From: Zac Denton
Sent: 24 January 2018 10:12
To: [REDACTED]
Subject: Y/1/18/TC

From: Ben Tidey [REDACTED]
Sent: 23 January 2018 13:32
To: Planning.Responses
Cc: [REDACTED]
Subject: RE: Further Information Required on Your Ref: PP-06643594 Our Ref: Y/1/18/TC

## BERRICOURT TREE PLAN

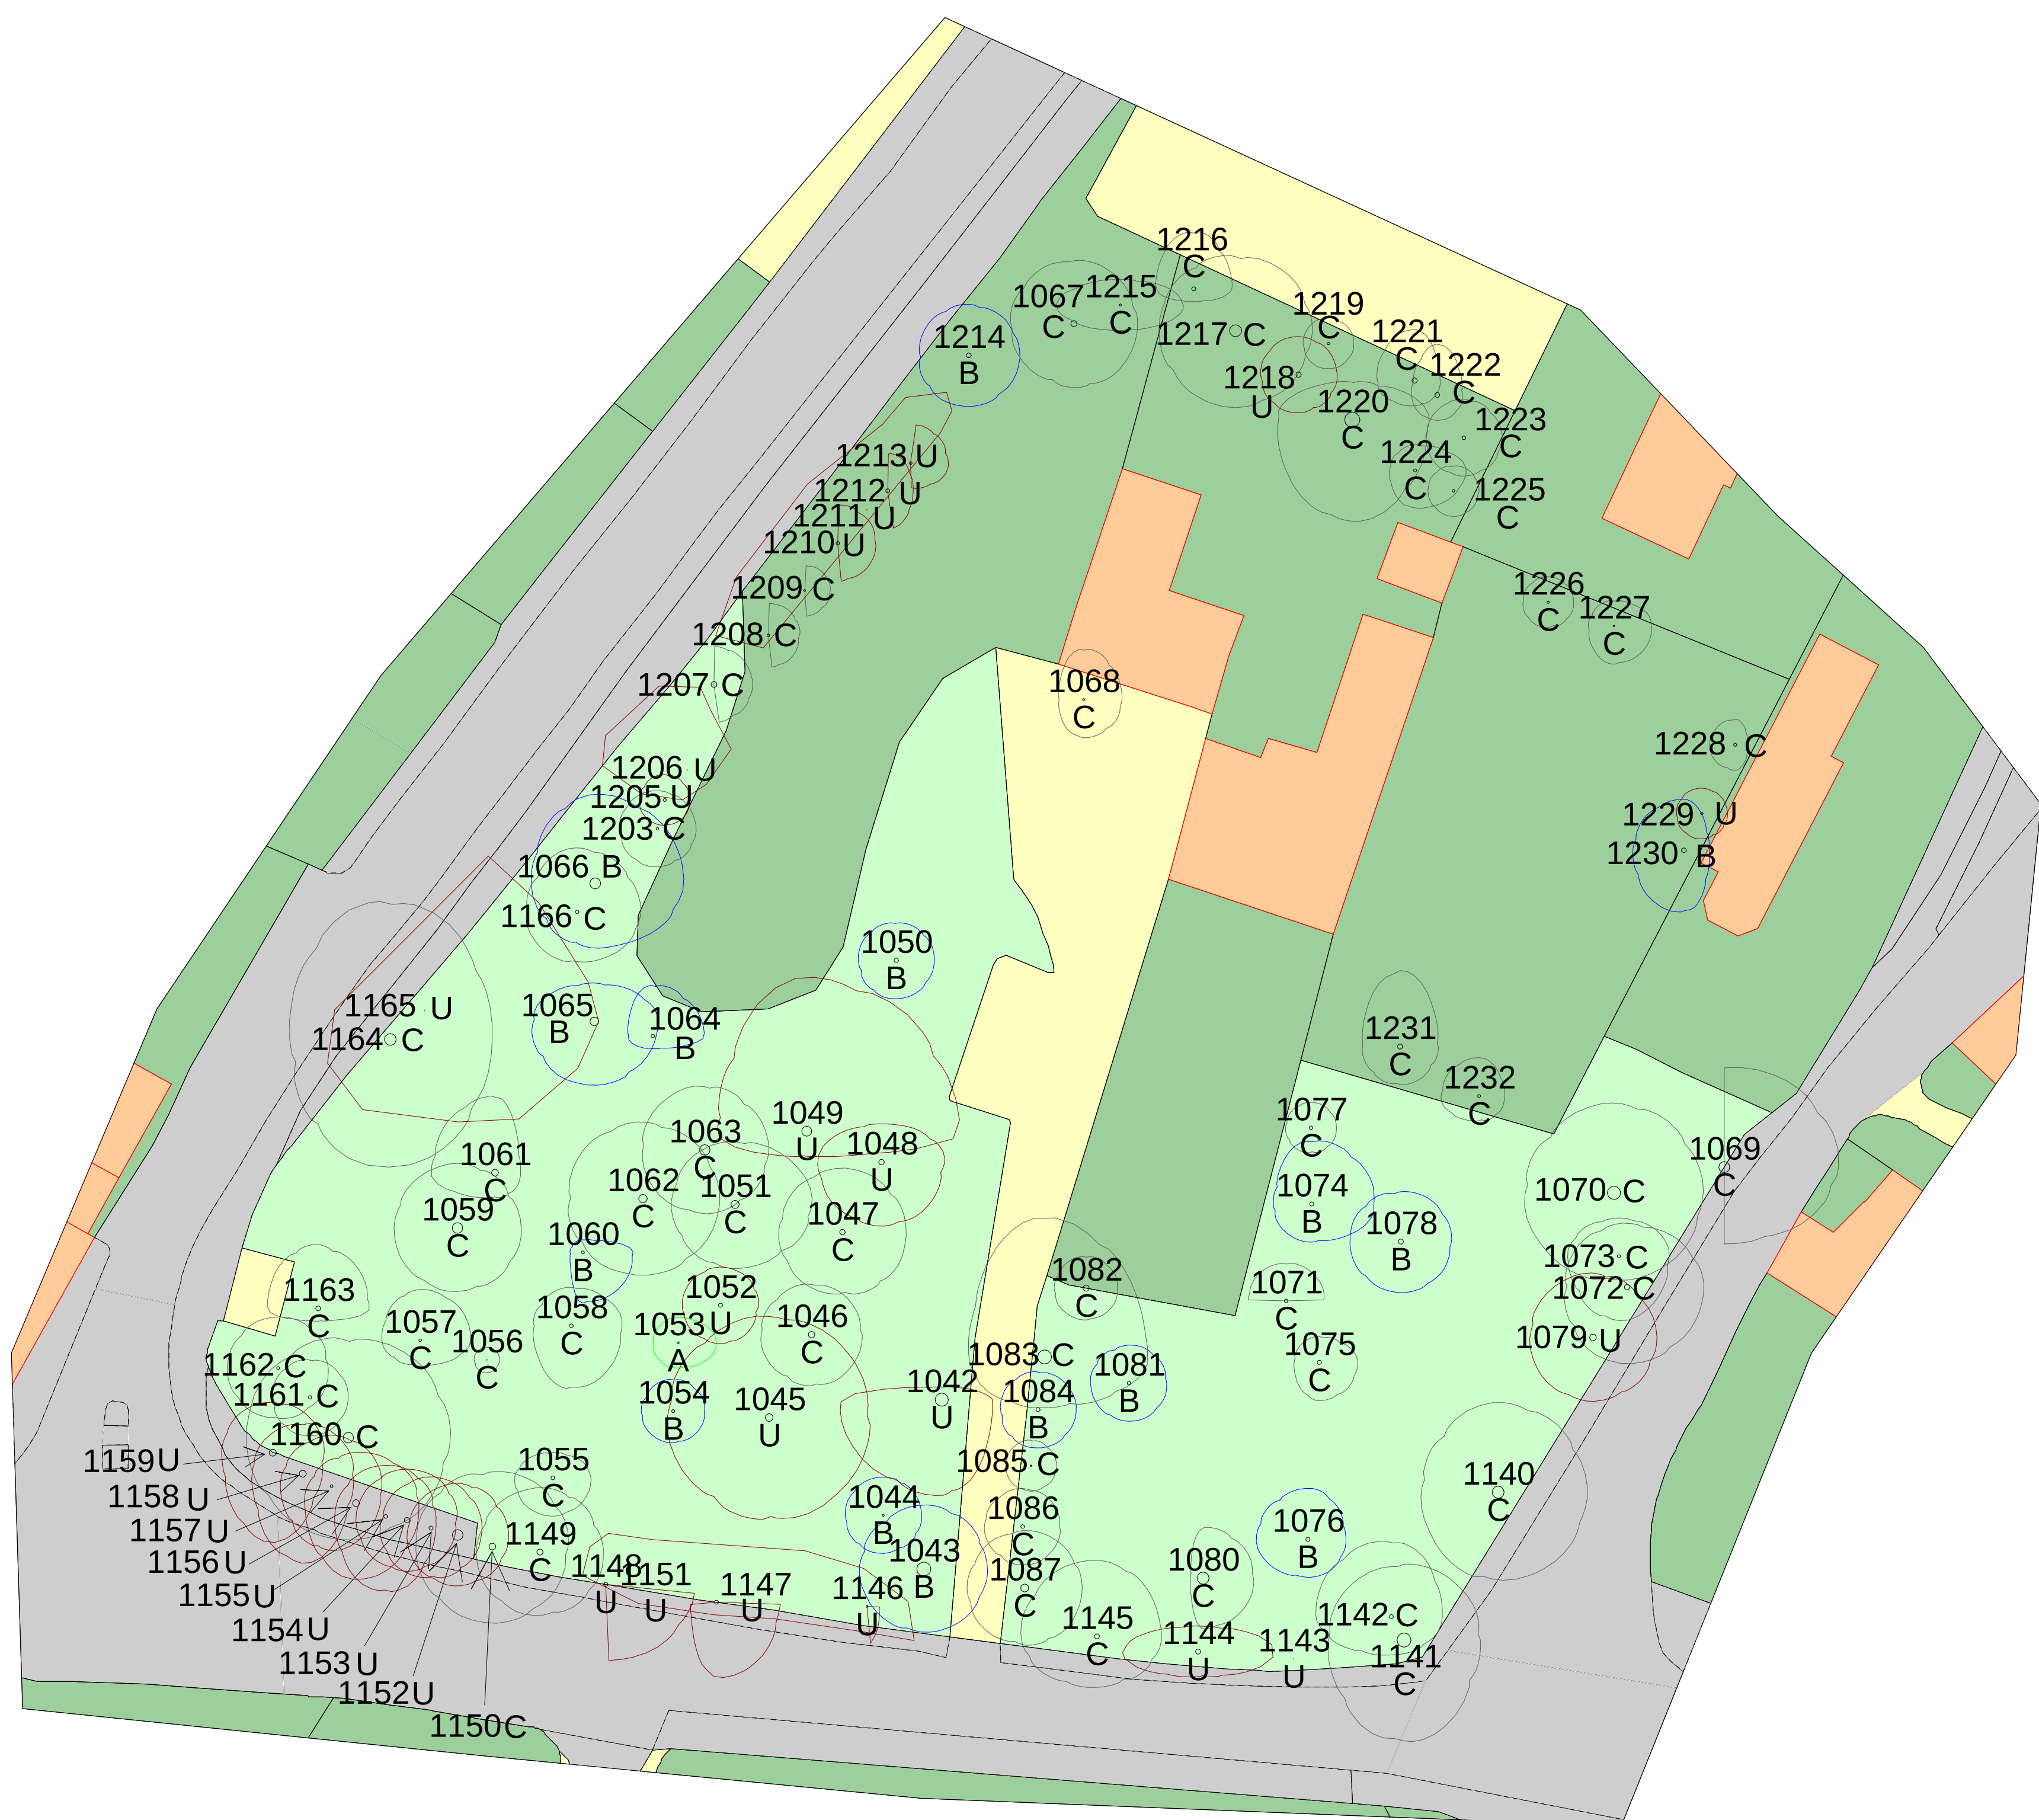
If the tree is dead then it can be removed from the application, you can write to our parks department to be issued with 5-day permission notice that relates to dead, dying or dangerous trees. Please inform me if you go ahead and do this, as then tree 1045 can be removed from the application.

Where you are asking "Please detail the number and species of trees in group" the reason for the grouping is that the groups are formed of outgrown hedging plants. There is a large number of stems (as would be expected of a hedge) of various sizes, the outgrown nature of these hedges means that there are now stems over 75mm@DBH. Are you after information on all stems over 75mm@DBH?

For tree 1045 the species is unknown as the tree is a standing dead stem that is covered in Ivy, so identification is not possible. I have included this tree in the request as it has a large trunk and with a height of 3.5m, this is included in the application to stop future issues relating from the tree removal. Should I remove this tree from the application as it is under the dead exemption criteria.
